From: Karen [REDACTED]
Sent: 30 October 2018 09:08
To: London Borough of Hillingdon
Subject: RE: Further Information Required on Your Ref: PP-07292988 Our Ref: R/237/18/HH

No I am not applying for a loft conversion, just the porch and little front extension

Subject: Further Information Required on Your Ref: PP-07292988 Our Ref: R/237/18/HH

SECTION A-A

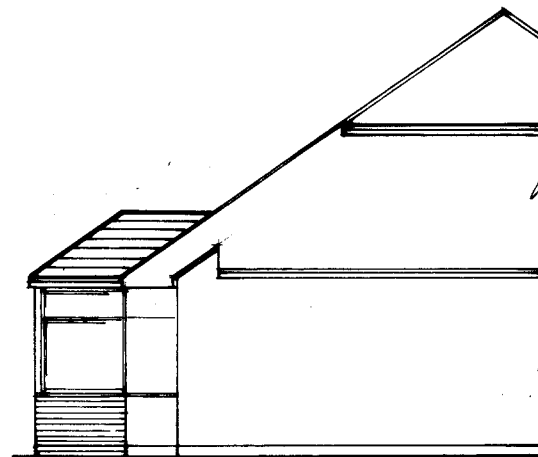
The proposed plan is also annotated with a 'proposed room' in the loft space on the section. Please can you confirm whether you are also applying for a loft conversion. If so, this will need to be included within the description. If you are not applying for this, please can you remove the annotation from the plan. Apologies this was missed from the original email.
